**WEST SUSSEX COUNTY COUNCIL
STRATEGIC PLANNING CONSULTATION**

DATE: 23 February 2018

SUBJECT: AB/148/17 – To provide 4no. detached houses on existing semi natural woodland site

Wooded Land South West of Dalloway Road, Arundel

1515 SK 10

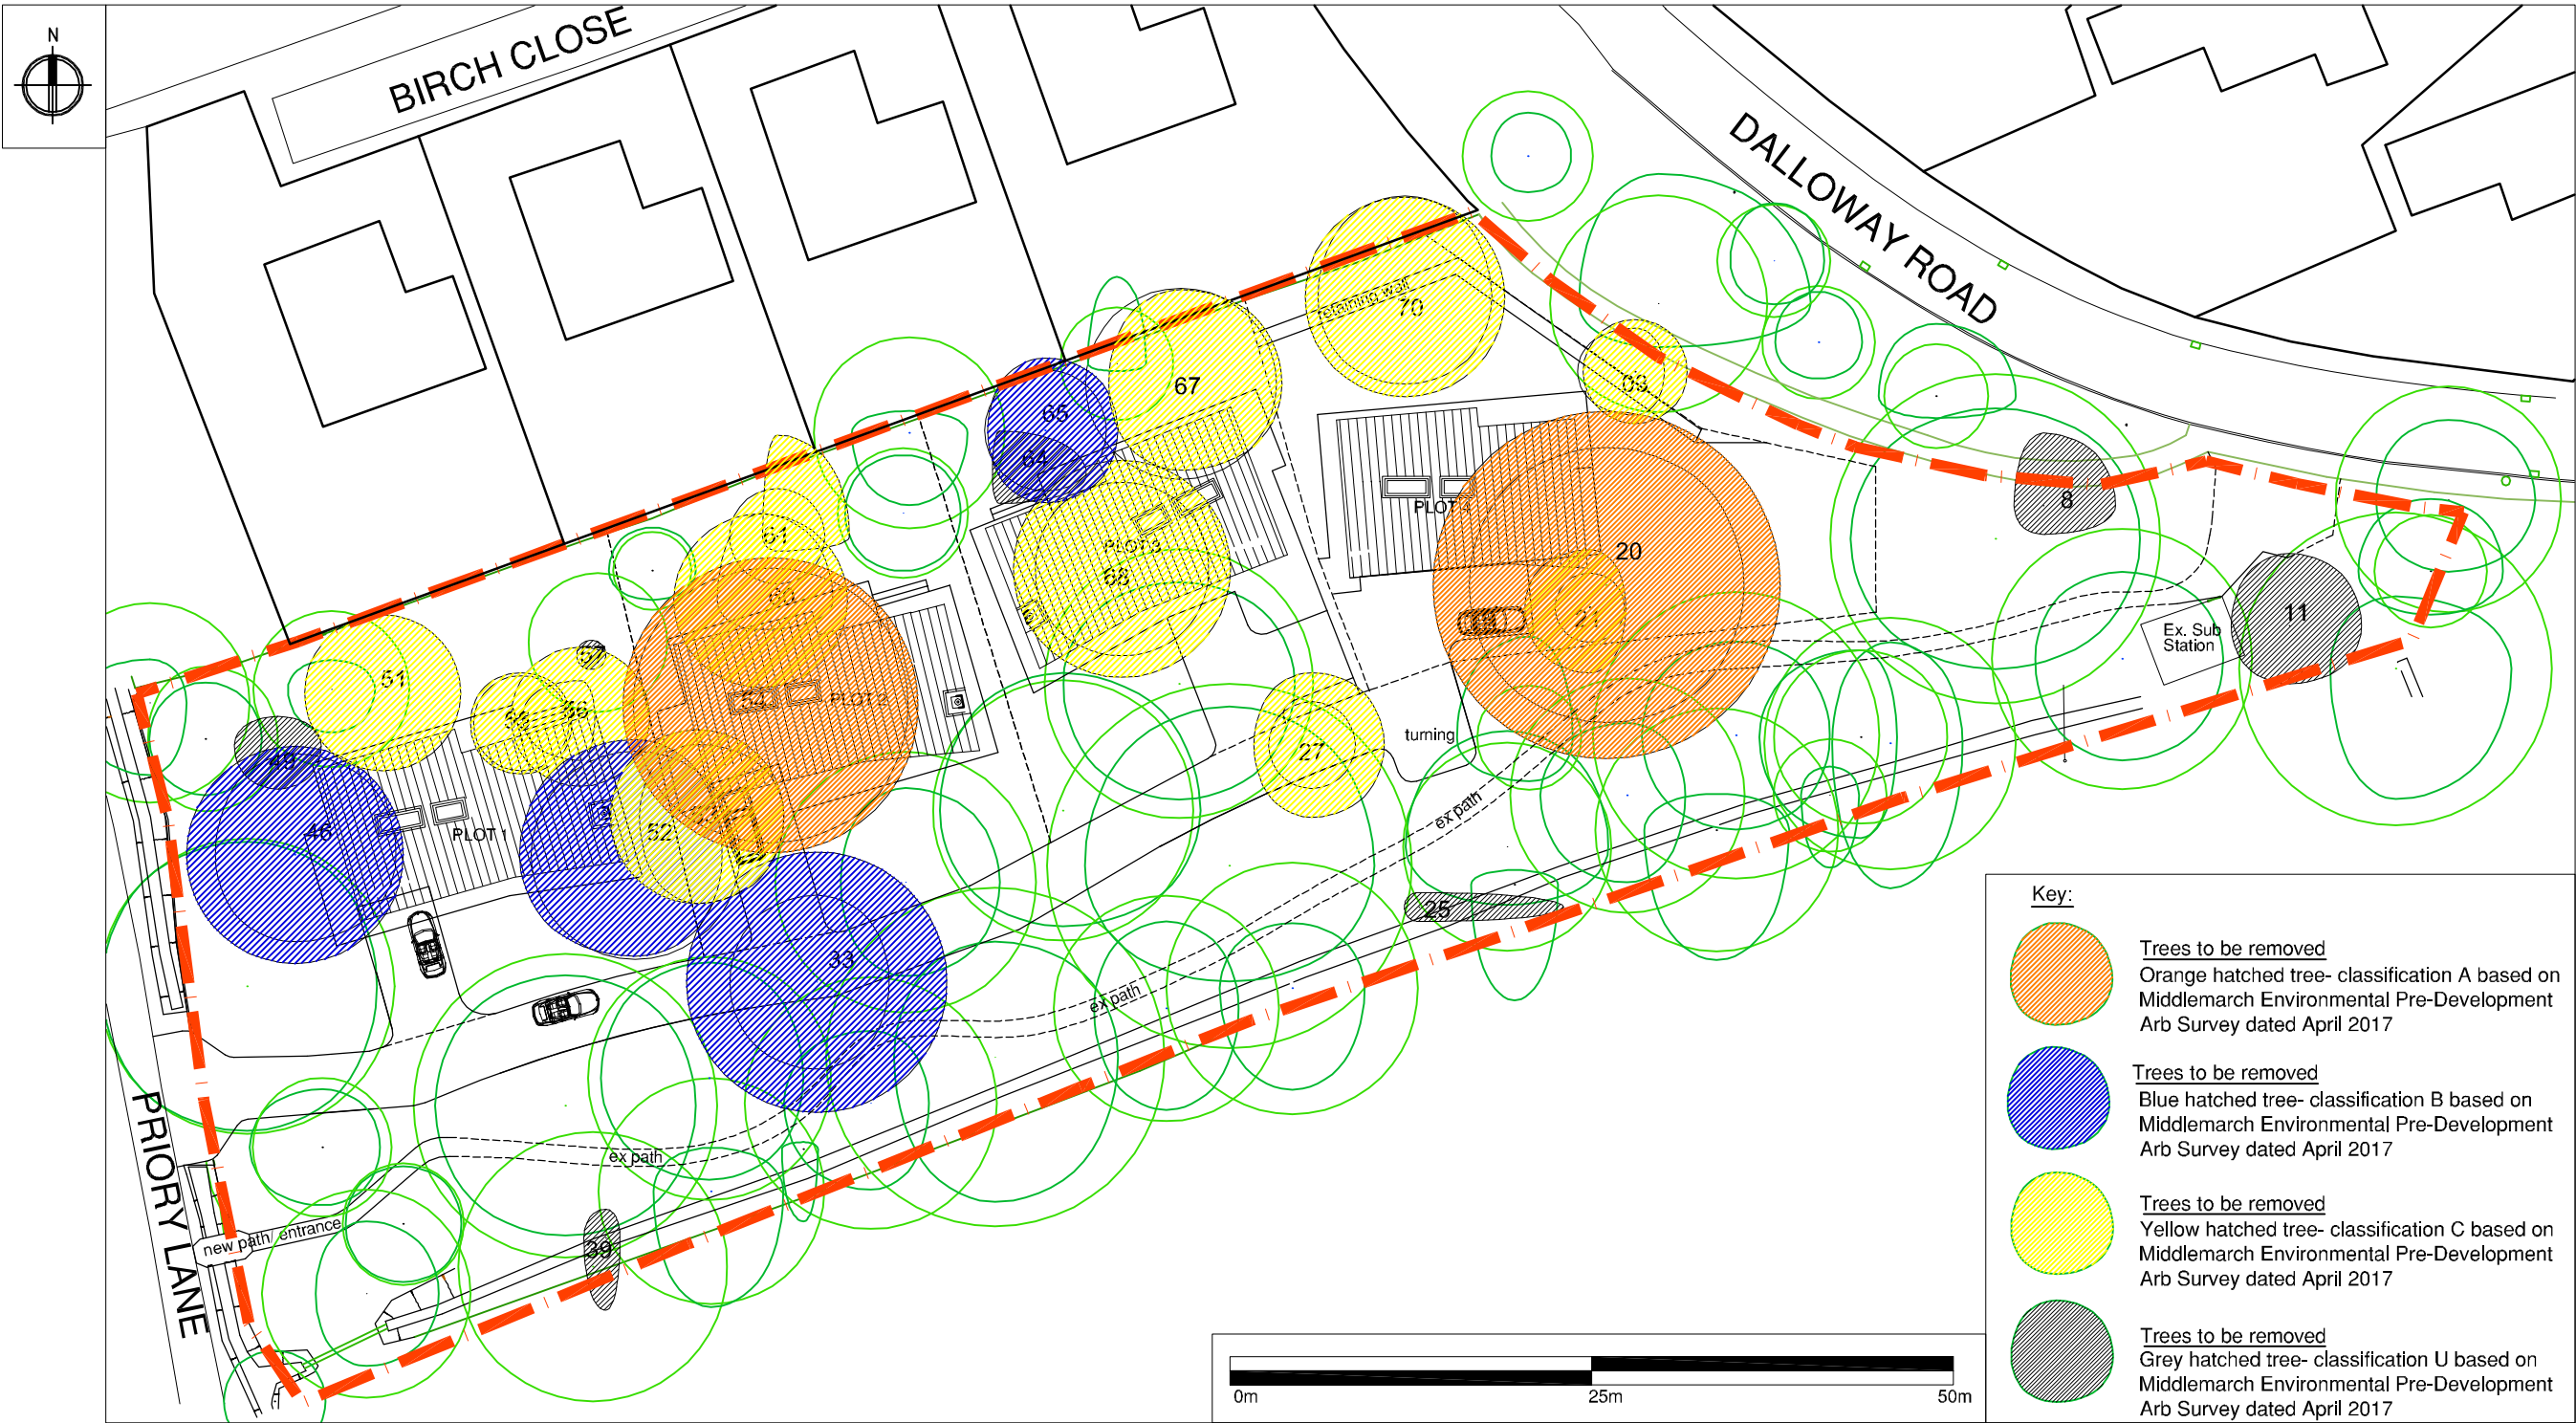
It is an offence to damage the surface of a PROW without the prior consent of the WSSC PROW service. The applicant proposes to remove a number of trees adjacent to FP342, access for which will at the very least disturb the path surface. All works affecting the path surface must be agreed with the WSSC PROW service prior to site works beginning. ADC is requested to add a suitably worded condition to any planning consent.
